From: Gemma Magnuson
Sent: 07 January 2021 10:32
To: DC Support
Subject: FW: 20/00948/LB and 20/00947/F

From: Joyce Christie <Joyce.Christie@Cherwell-DC.gov.uk>
Sent: 17 December 2020 19:38
To: Gemma Magnuson <Gemma.Magnuson@cherwell-dc.gov.uk>
Subject: 20/00948/LB and 20/00947/F

WINDOW TO GARAGE GABLE

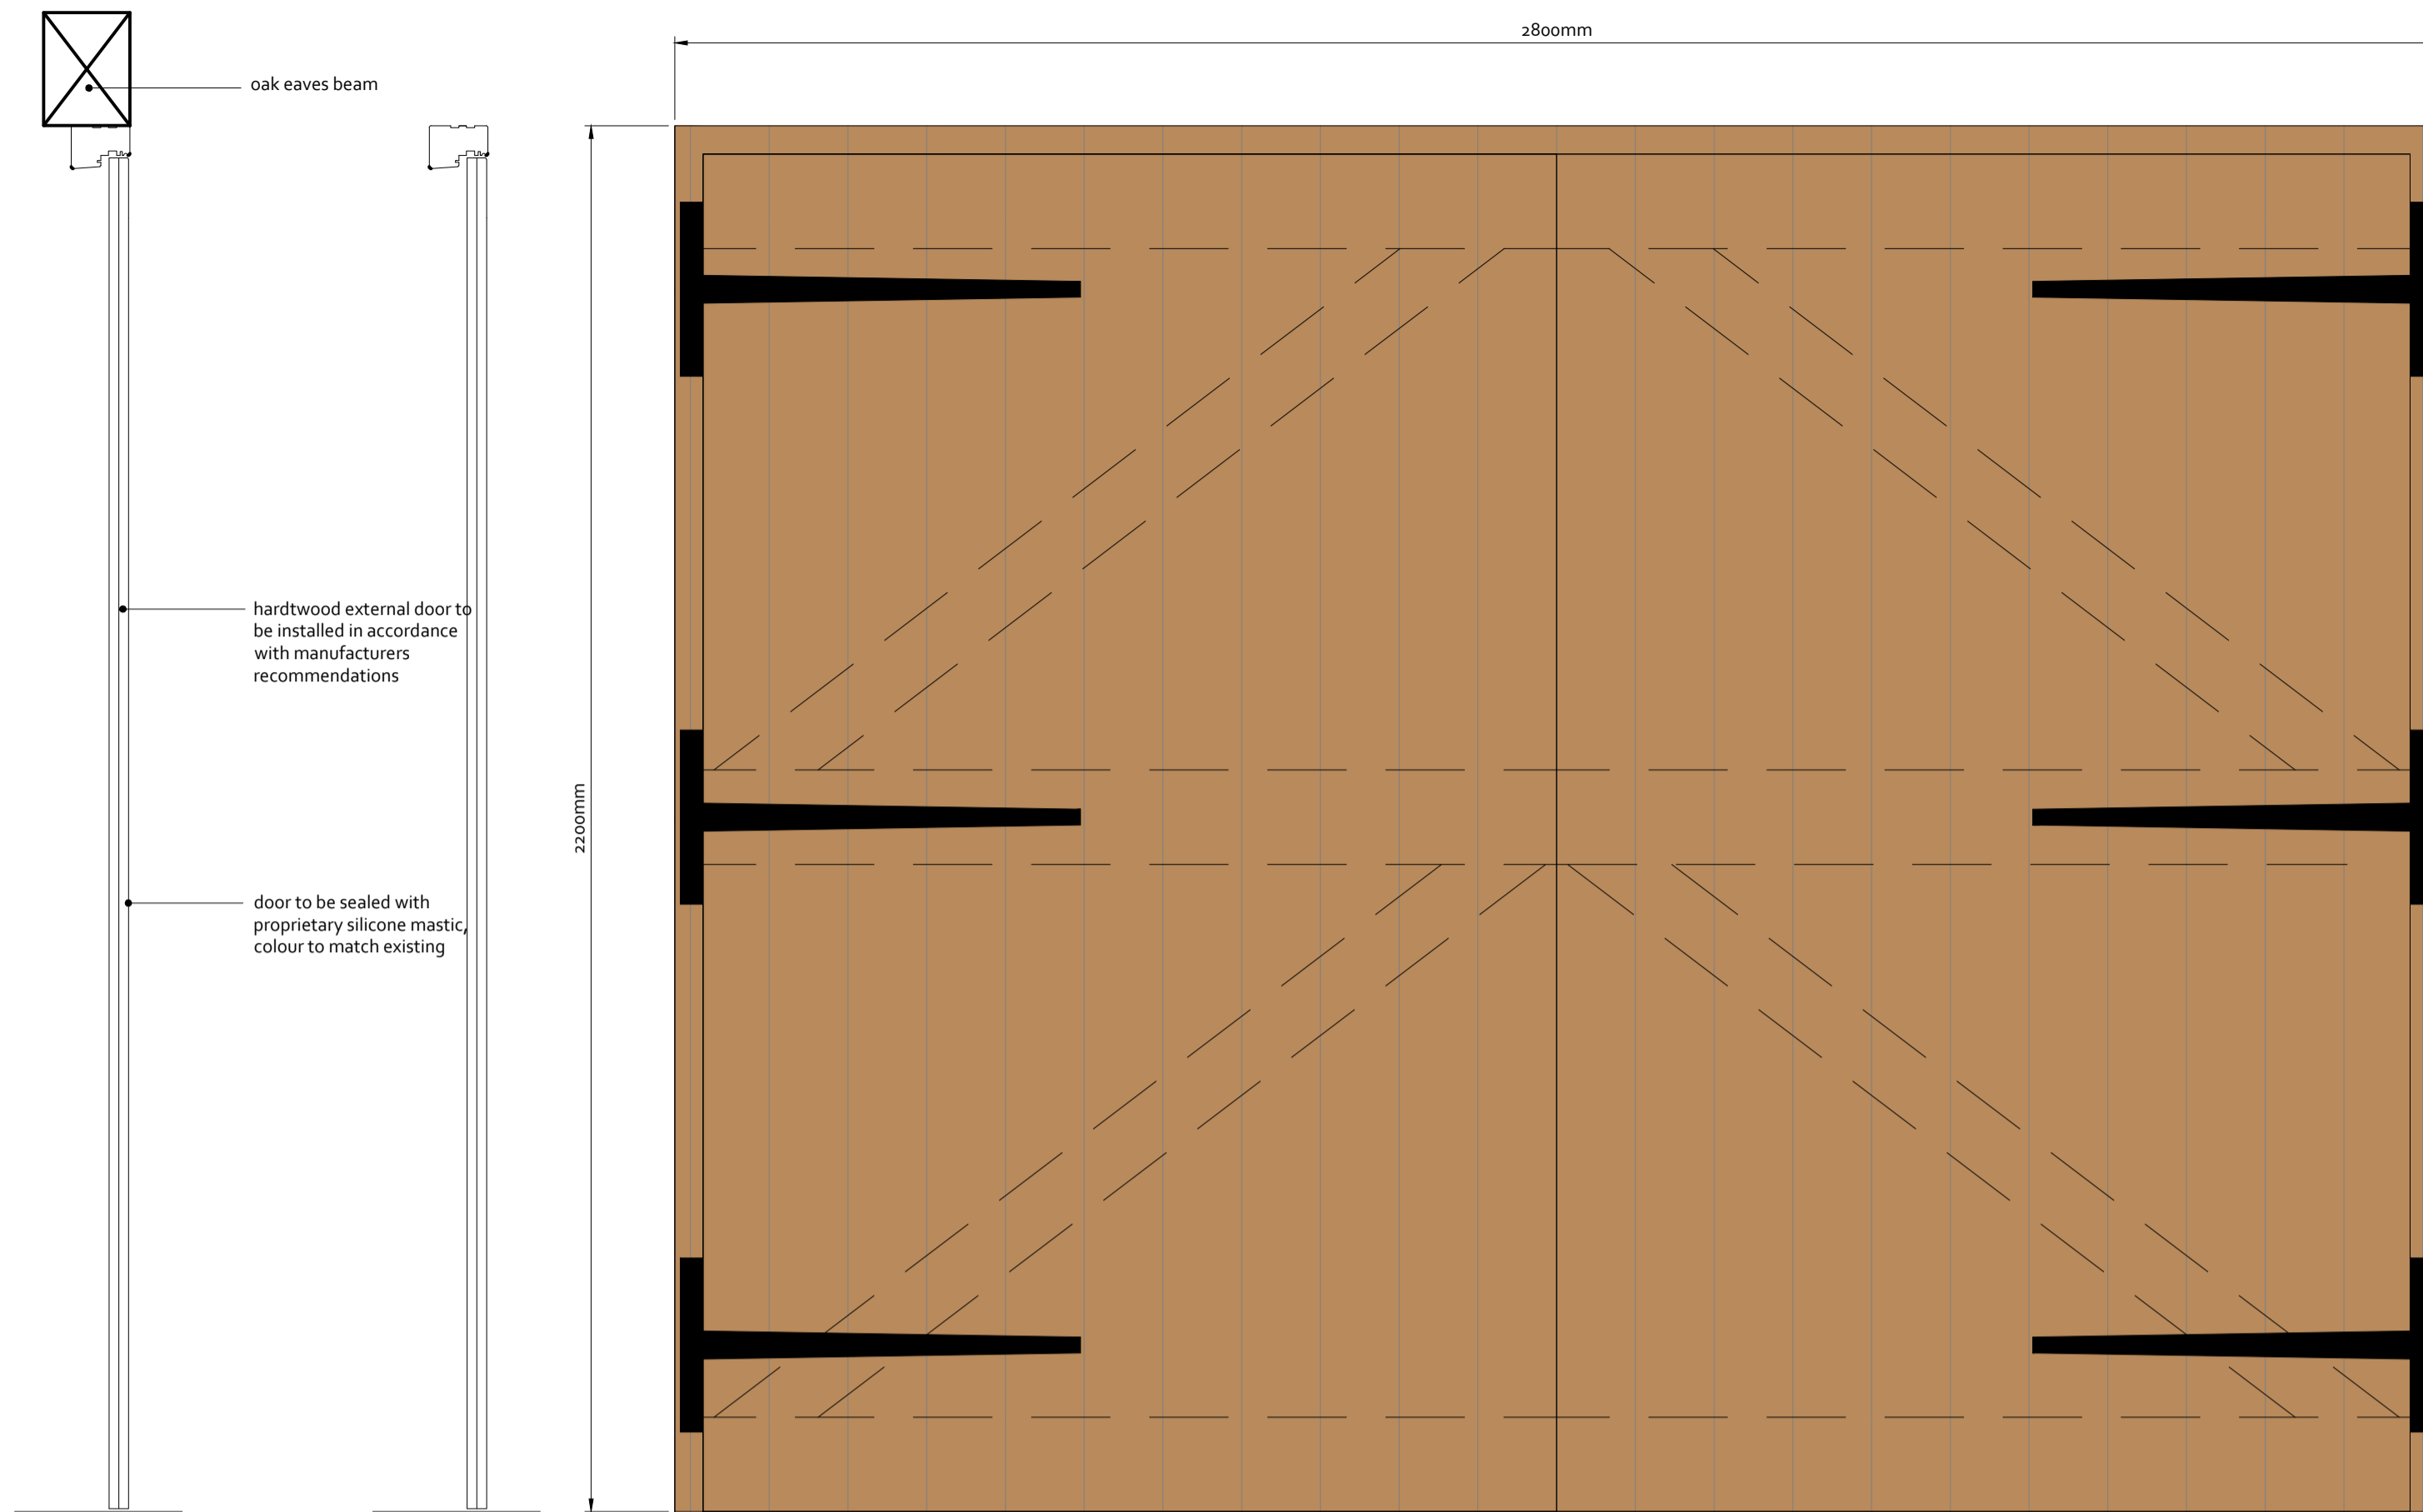
As this is a different building I think we should ask for a new masonry panel taking on board my comments about the mortar/joints widths. If you can't get a new panel can you recommend they tighten the joints and use a lime mortar so the mortar is sacrificial to the stone please
